From: Keri Matthews [REDACTED]
Sent: 28 October 2020 12:08
To: Daun Johnson <Daun.Johnson@arun.gov.uk>
[REDACTED]
Subject: Re: WA/65/20/PL - Planning PDF's

EXISTING LEFT (ANGLE ELEVATION)
(AND FLOORS)

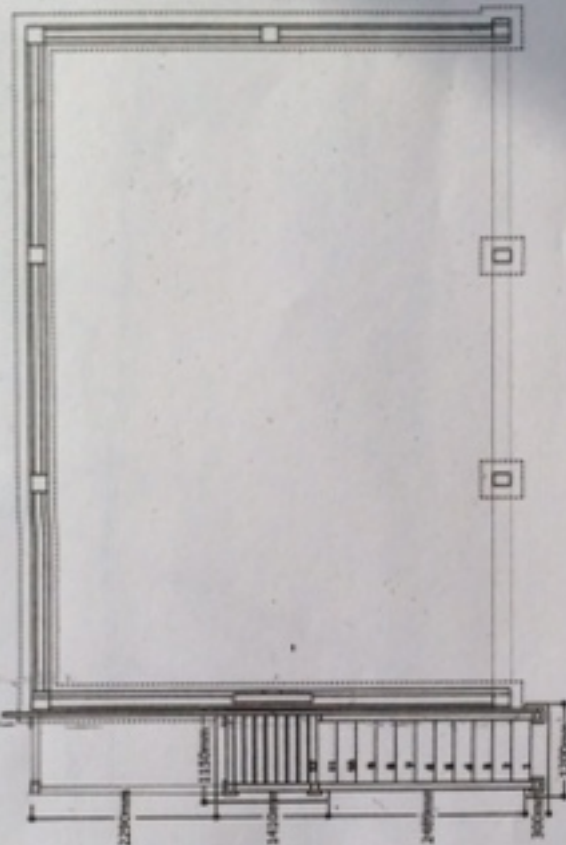
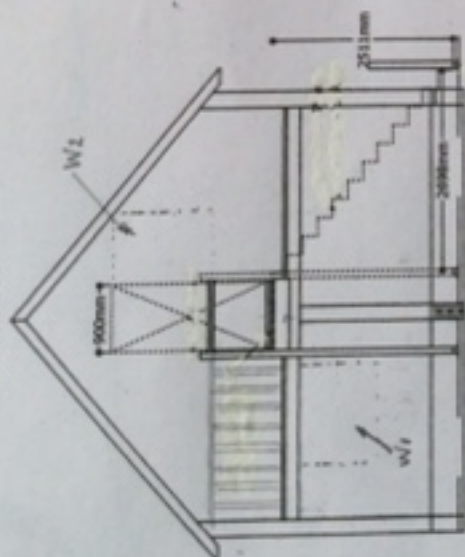
The location and block plans are not scaling correctly as the floor plan and elevations are not scaling correctly.

PROPOSED : Garage

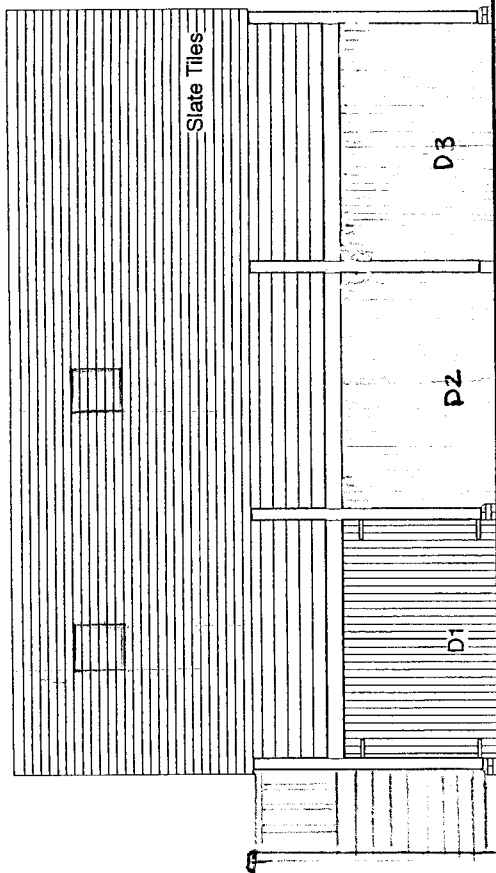
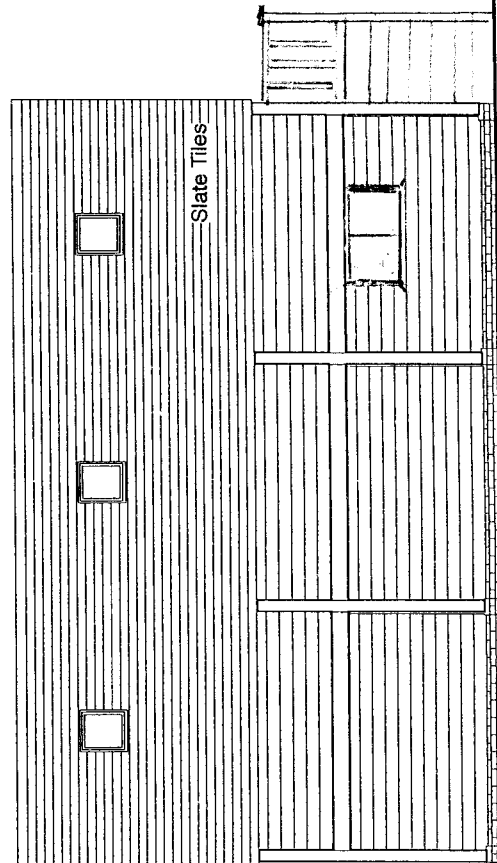
The elevation plan needs to have a scale or measurements (length, height in metric) and to be labelled as existing and/or proposed. I also require the two side elevations of the garage with a scale or measurements. If there is no operational development on the side elevations, one plan labelled existing and proposed side elevations will suffice.
